from
**Southern
Water**

Your ref
AL/49/22/PL

Proposal: Demolition of all existing buildings and structures and redevelopment of the existing car salvage and recycling facility to provide 80 No dwellings and a co-working hub, with vehicular access from Fontwell Avenue, provision of public open space, landscaping, and other associated works. This application is a Departure from the Development Plan is in CIL Zone 3 and is CIL Liable as new dwellings.

Site: AL/49/22/PL: - Sussex Recovery Company, Fontwell Avenue, Eastergate PO20 3RU.

SOUTHERN WATER

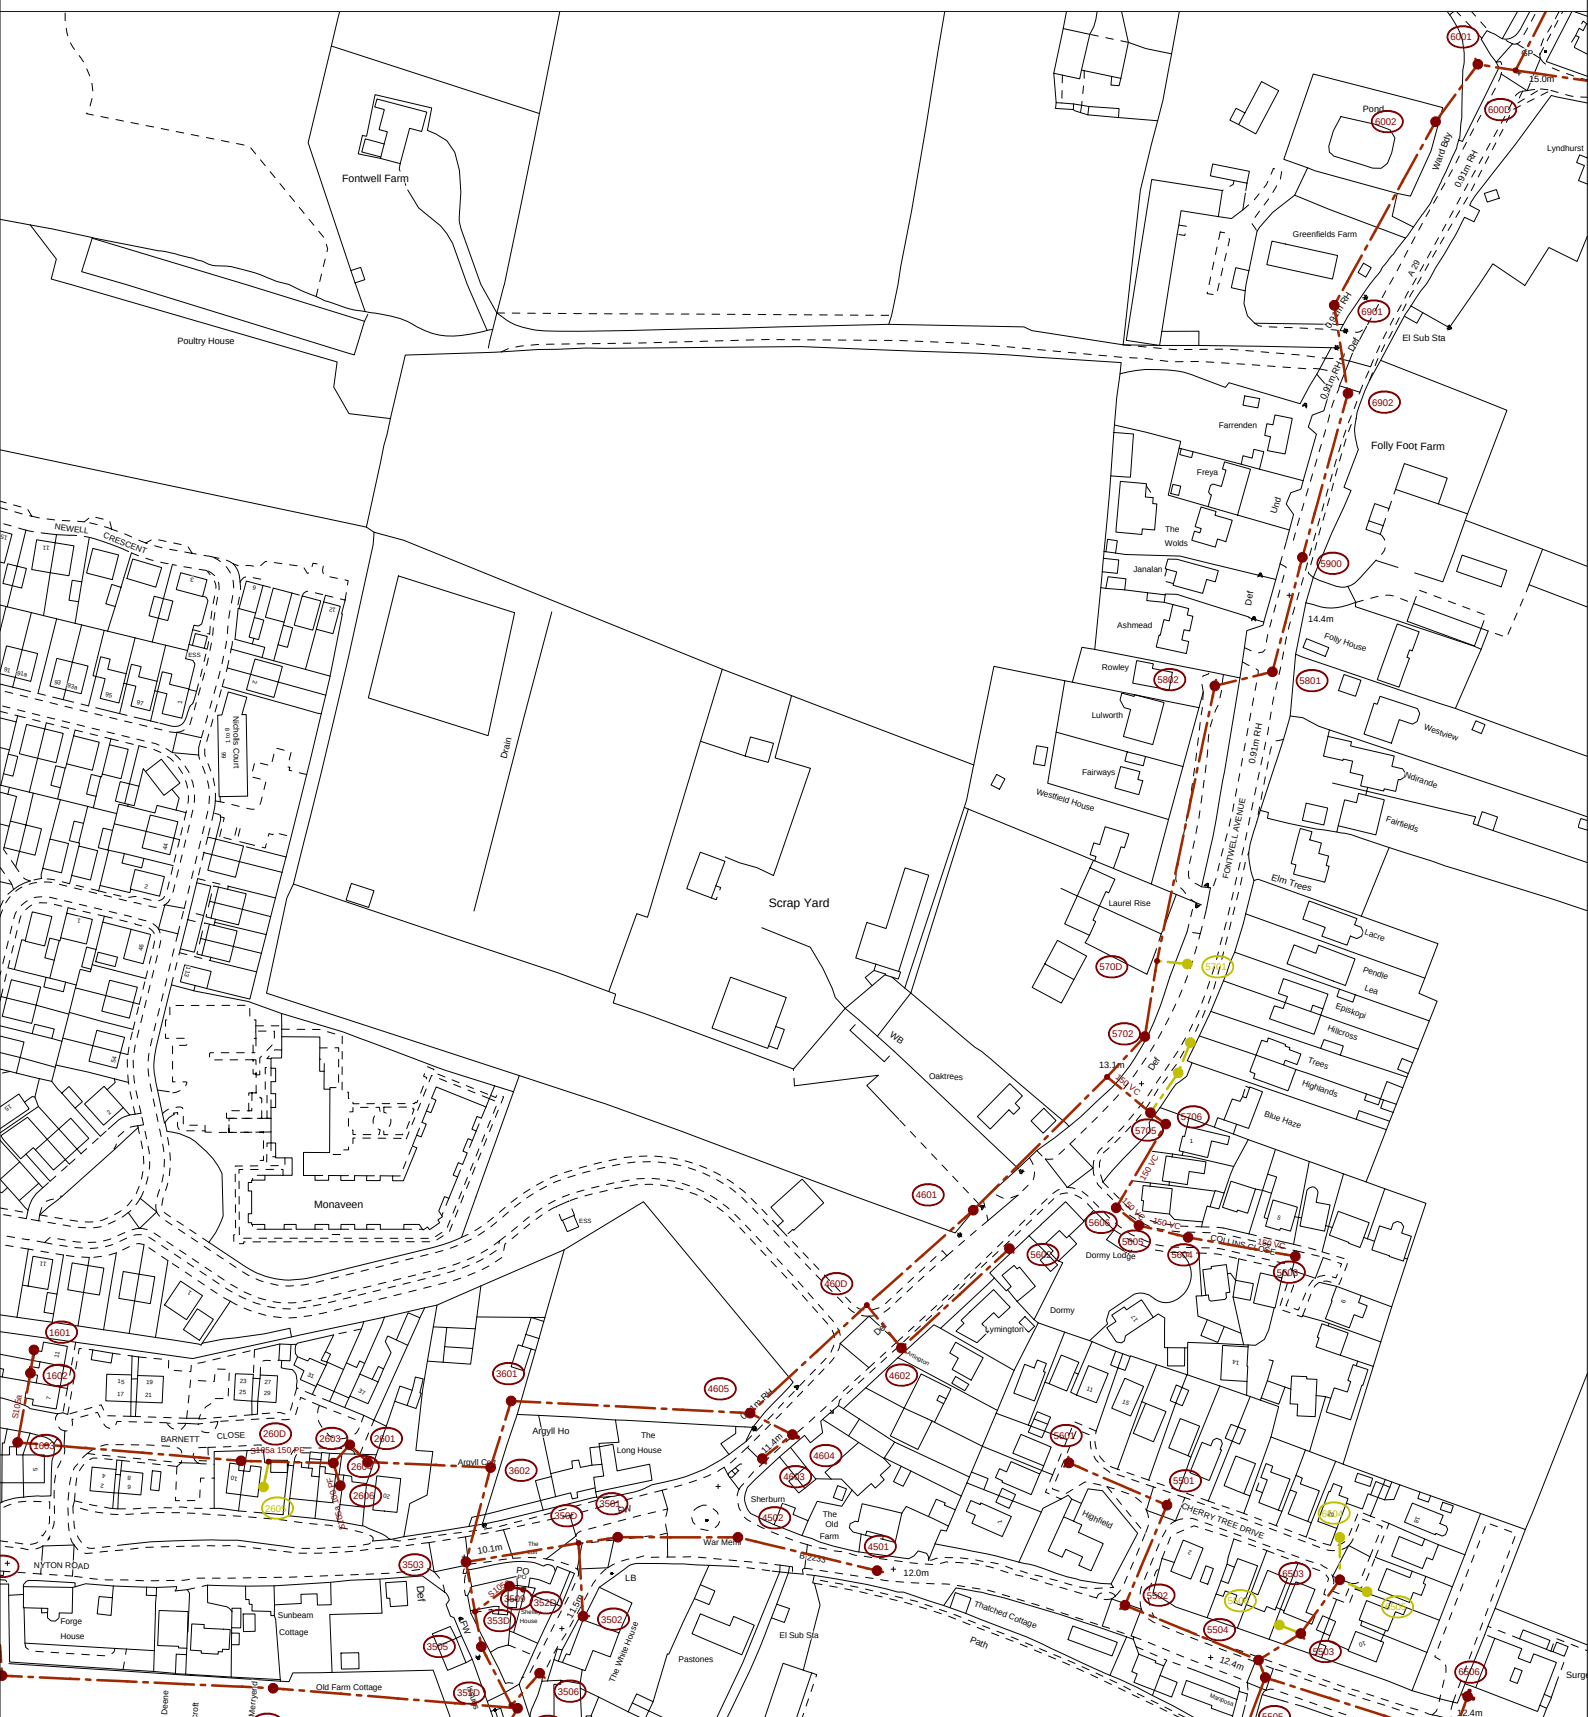
Please see the attached extract from Southern Water records showing the approximate position of our existing public foul sewer asset within the development site. The exact position of the public assets must be determined on site by the applicant in consultation with Southern Water before the layout of the proposed development is finalised.

- The 225 mm public foul sewer requires a clearance of 3 metres on either side of the gravity sewer to protect it from construction works and to allow for future access for maintenance.
- No new development or tree planting should be carried out within 3 metres of the external edge of the public gravity sewer without consent from Southern Water.
- No new soakaway, swales, ponds, watercourses or any other surface water retaining or conveying features should be located within 5 metres of a public sewer.
- All existing infrastructure should be protected during the course of construction works.
